# Rezoning Transportation Analysis

Petition Number: 2022-117

General Location Identifier: 03515518, 03515519, 03515521

Date	Description
12-28-22	First Review (TM)

REZONING PLAN
RZ.01

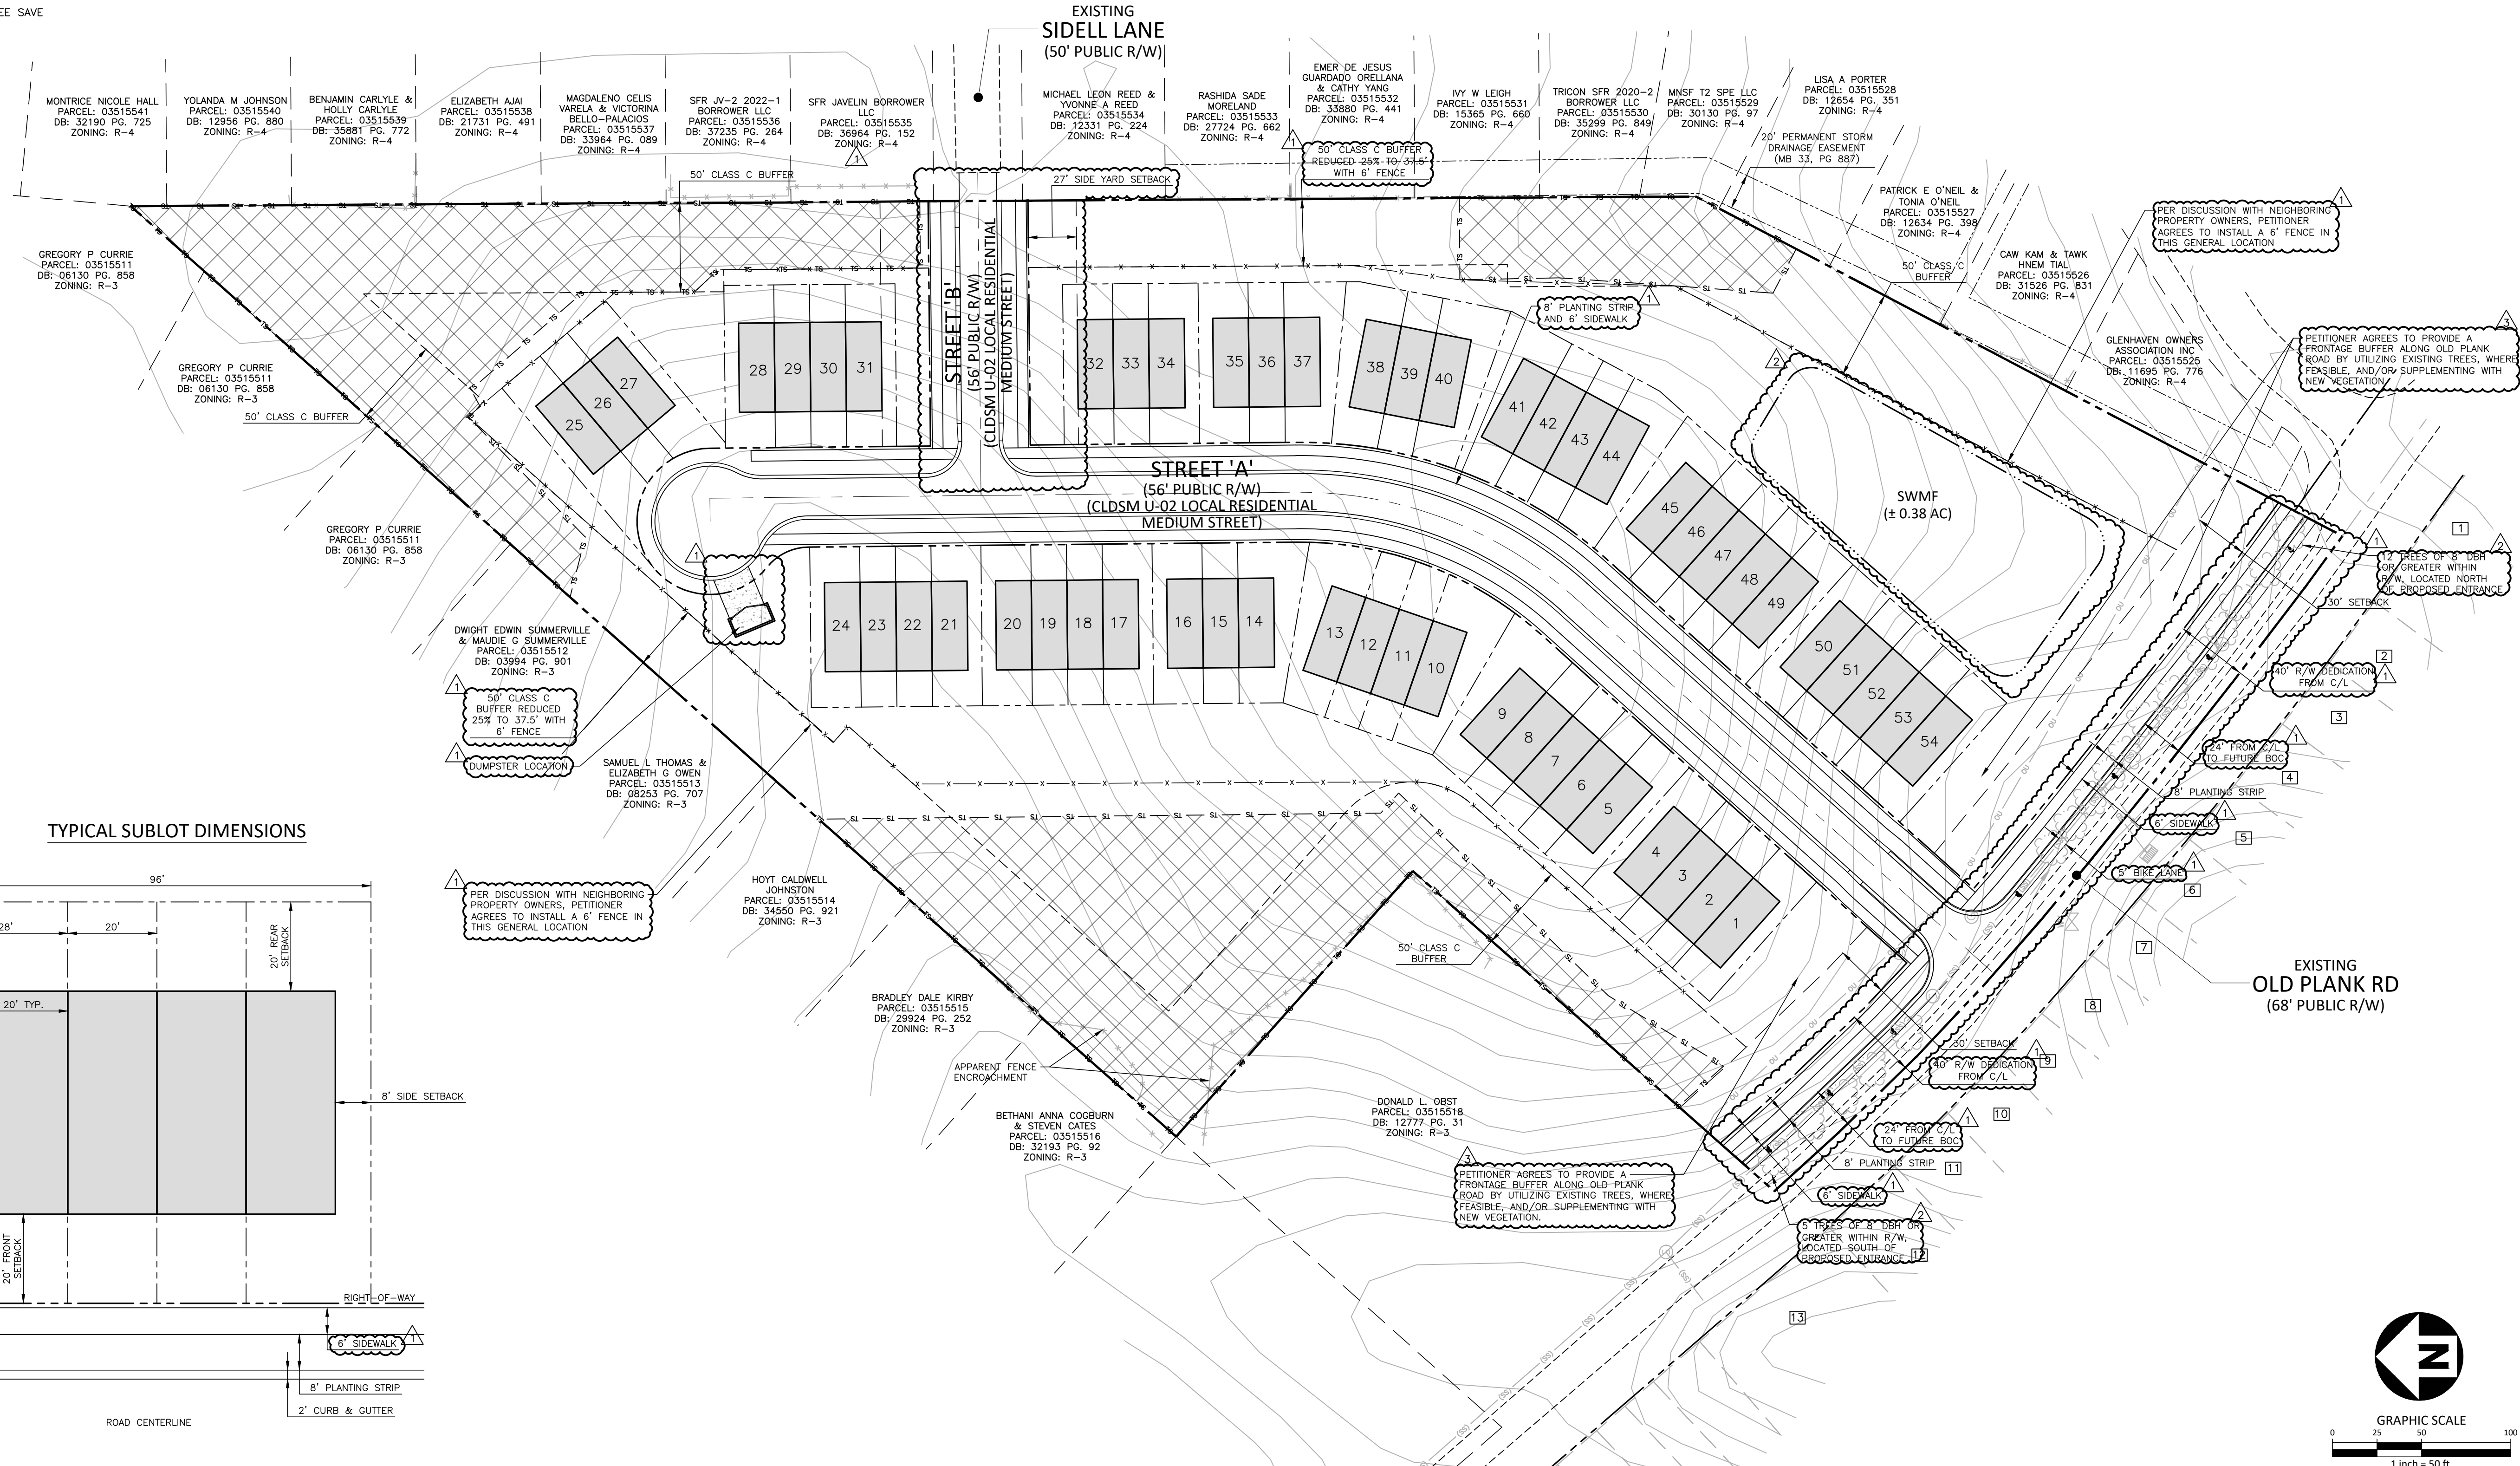
- a. **Old Plank Road:** Location of back of curb and gutter to be moved to 24 feet from roadway centerline to accommodate the Charlotte Streets Map with a roadway typical section of CLDSM 11.09 Minor Thoroughfare.

Label and dimension the curb and gutter from the centerline for each road on the site plan.

3. Revise site plan and conditional note(s) to commit to construct an 8-foot planting strip, and 6-foot sidewalk on all proposed public roads per Chapter 19. The site plan shall label and dimension both items from the back of curb and gutter or edge of pavement.

4. Revise site plan and conditional note(s) to commit to construct bicycle facilities by locating the back of curb and gutter 24' from the center line and installing a 5-foot bike lane on Old Plank Road to meet the Council-adopted Charlotte BIKES Policy.

6. Revise site plan and conditional note(s) to commit to completing the connection to Sidell Lane. Site plan shall show existing Sidell Lane and roadway infrastructure connecting to the proposed public roadway.
